Single storey side extension
2 Green Park Ferring

Thank you for your internet comments made on 8th October 2019 which has been recorded as **'an objection'** with the comments as follows:

Drawing Title
EXISTING & PROPOSED PLANS,
SECTIONS, SITE PLANS
& ELEVATIONS

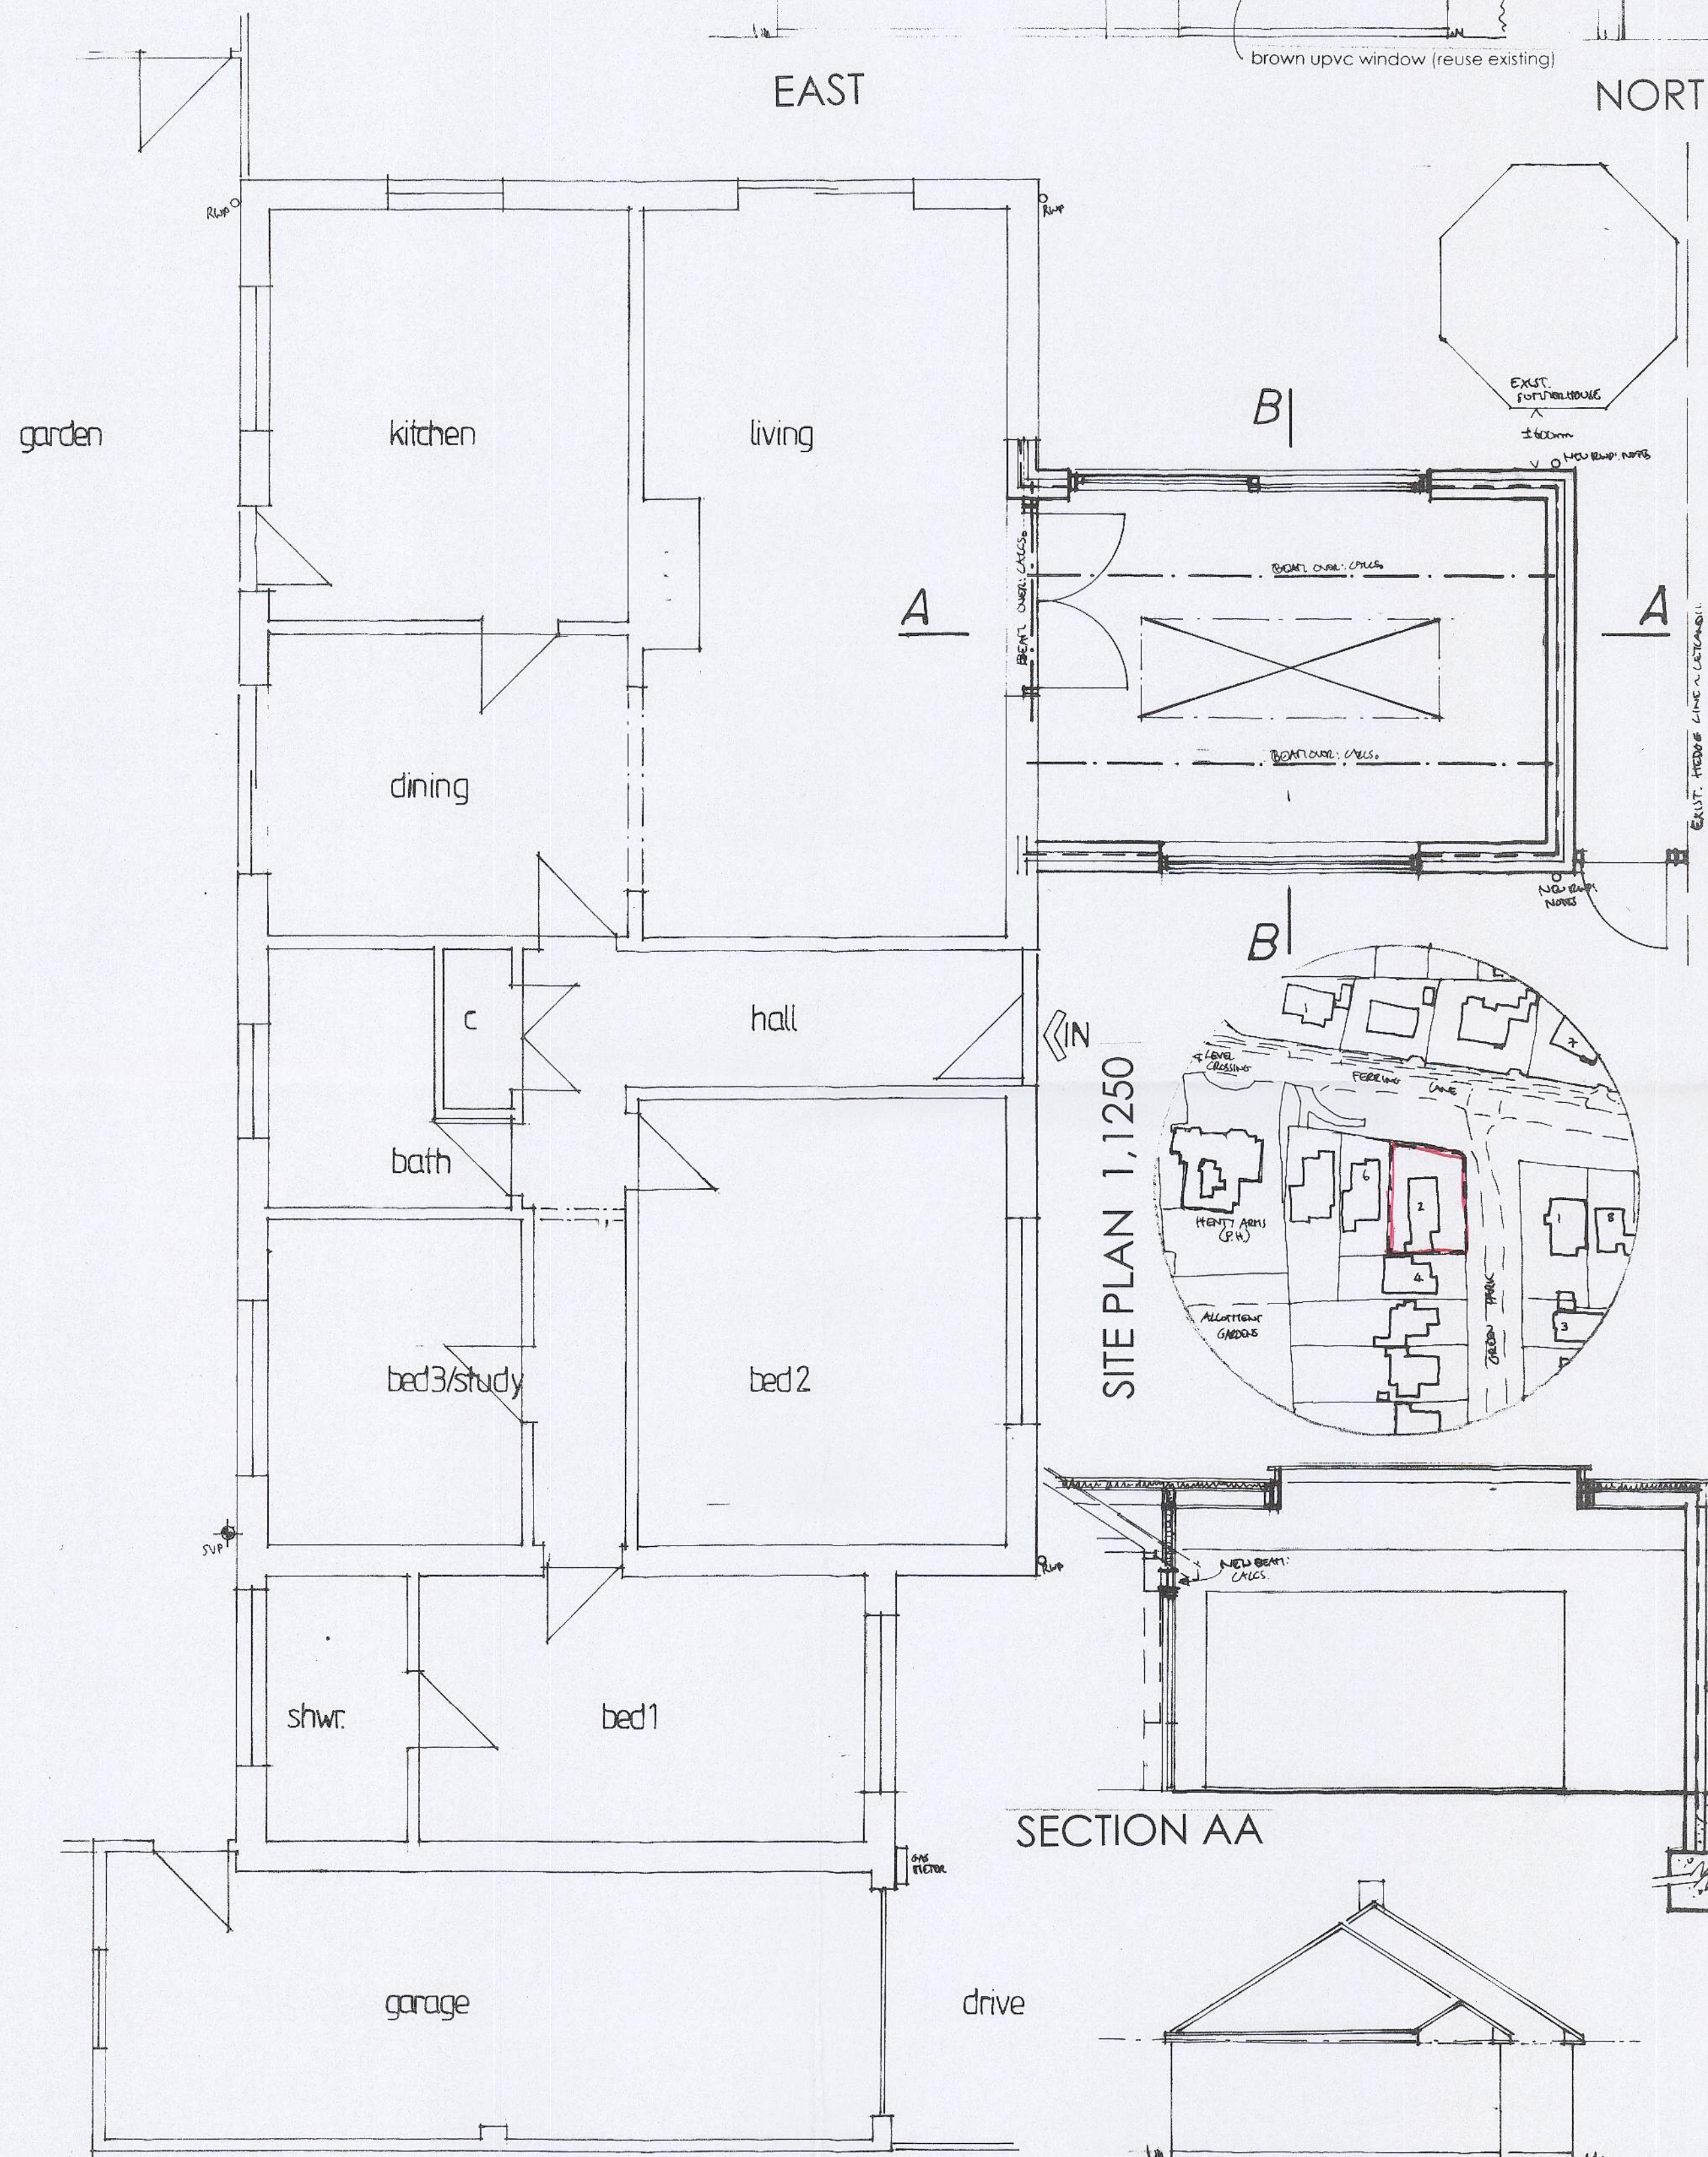
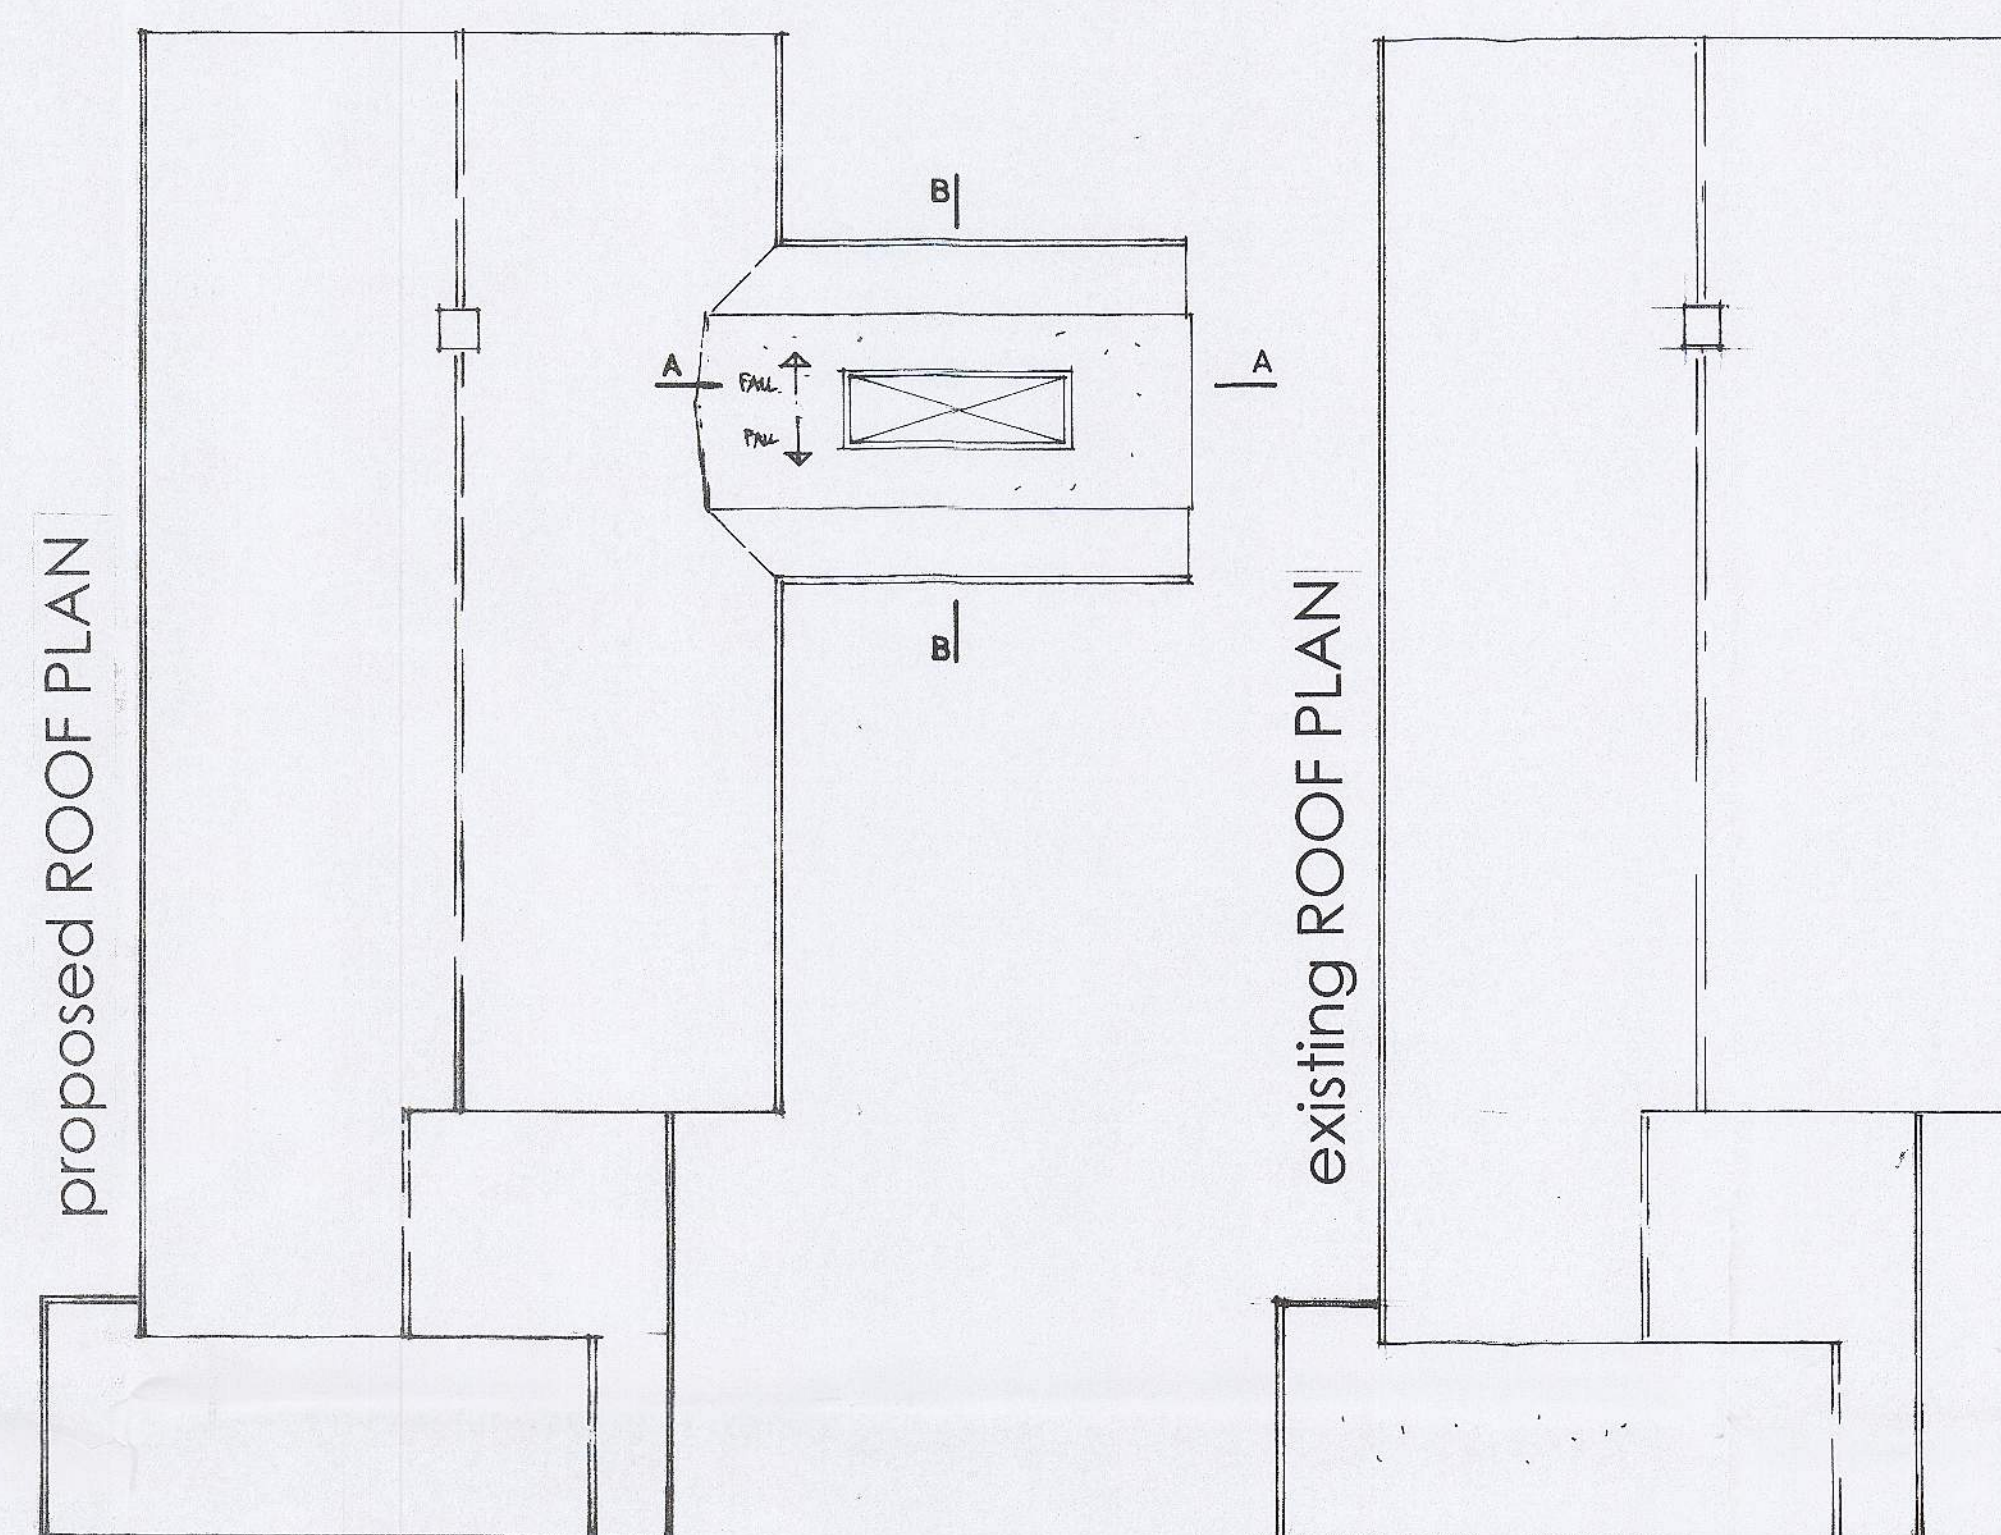
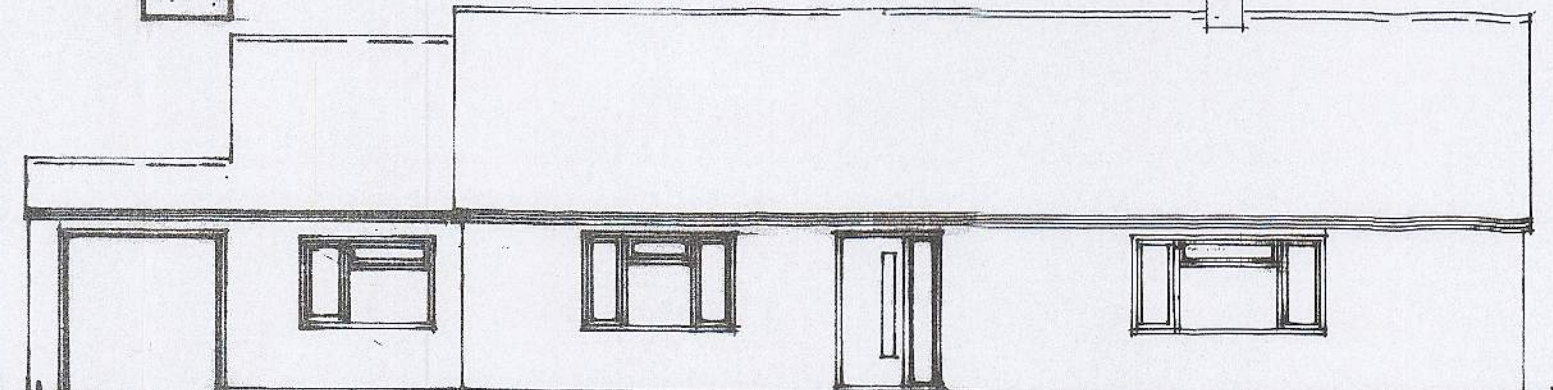
Ferring Parish Council object to this application as the proposed extension would have an overly dominant impact on the street scene contrary to policy D DM1. The positioning of such a large extension would be out of keeping and out of character with the open garden aspect of Green Park, severely impacting the line of sight for the road contrary to policy D SP1.
